Conservation Area Advisory Committee

Meeting Date : 5th June 2017

BR/113/17/PL	Construction of an adventure golf course, kiosk, car park extension & conversion of existing kiosk into 2 No. WCs. This application affects the Upper Bognor Road & Mead Lane Conservation Area.	Putting Green Hotham Park Upper Bognor Road Bognor Regis PO21 1HN
--------------	--	--

02 PROPOSED
AMENITIES

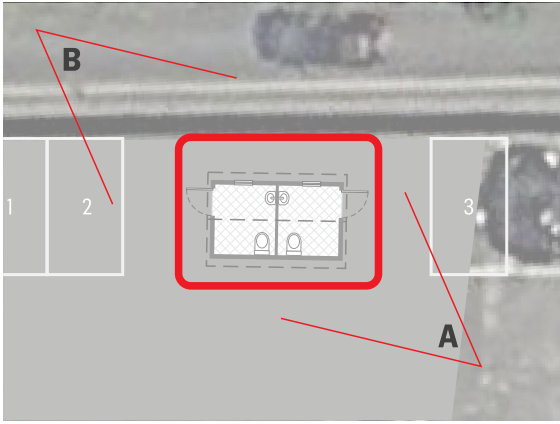
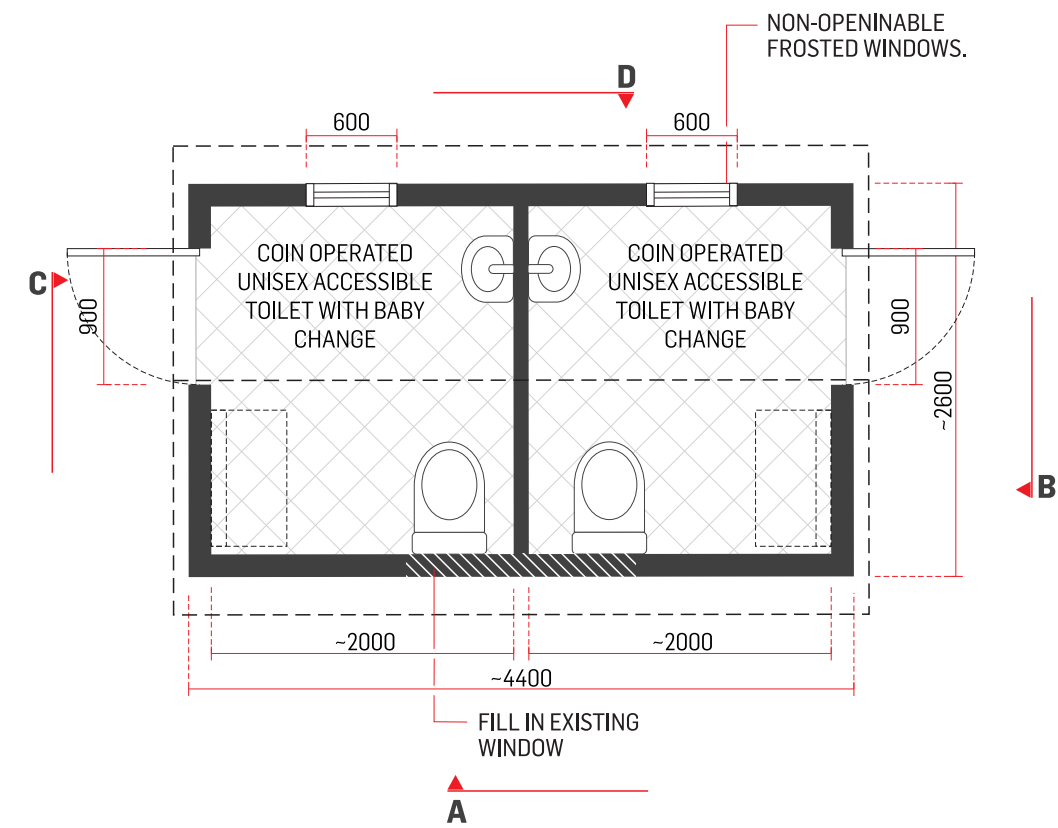
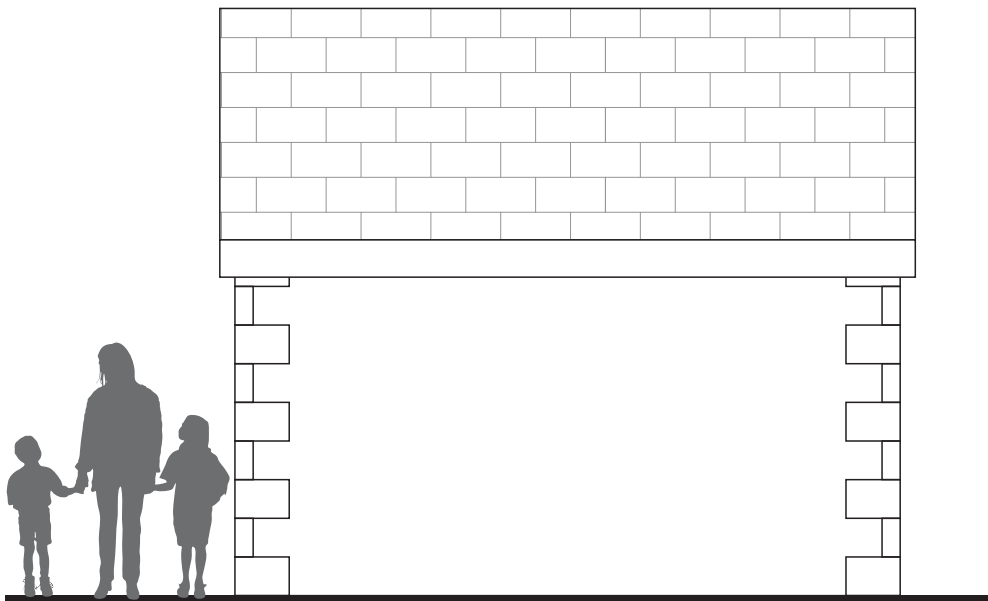
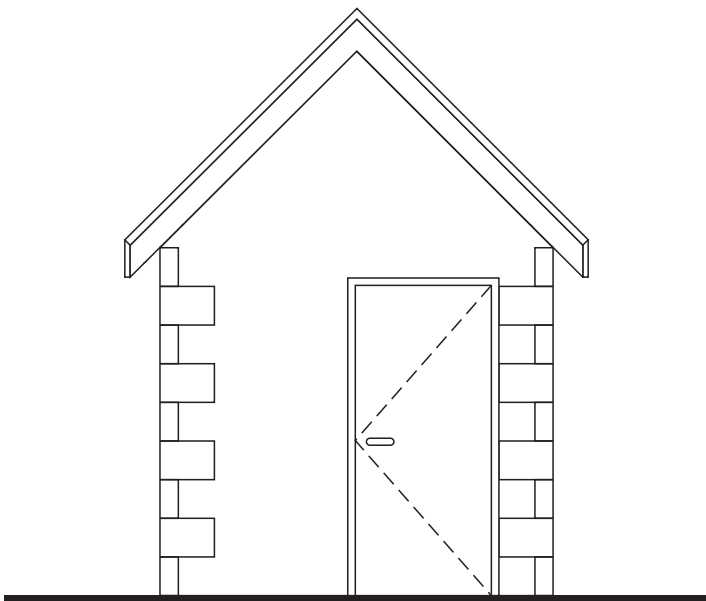
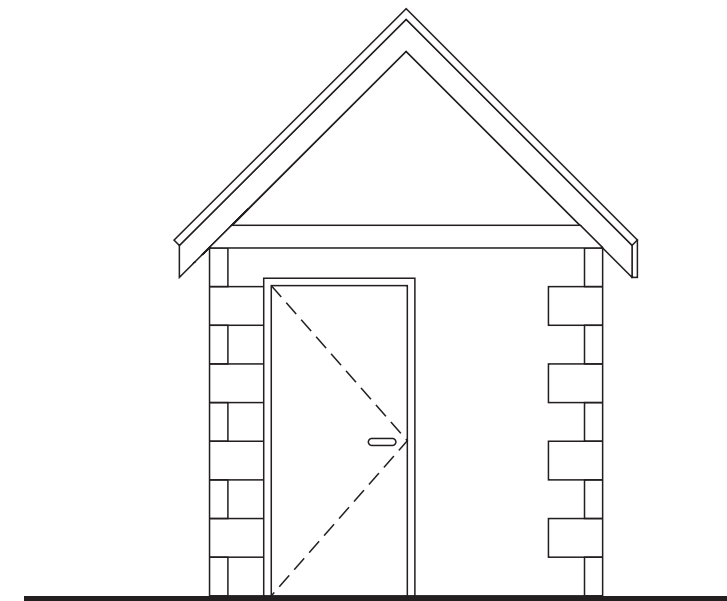
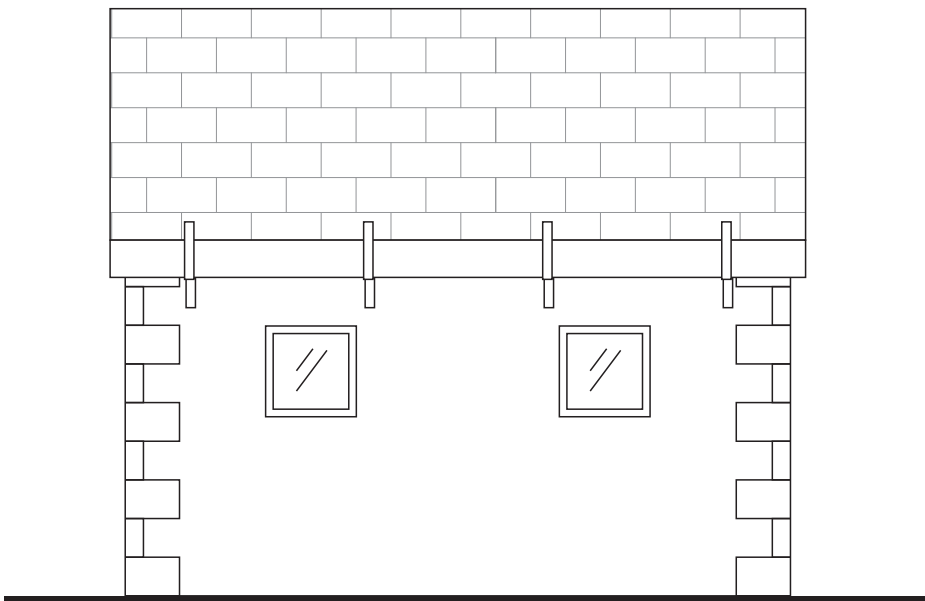
New kiosk should be in same style as proposed W.C.s
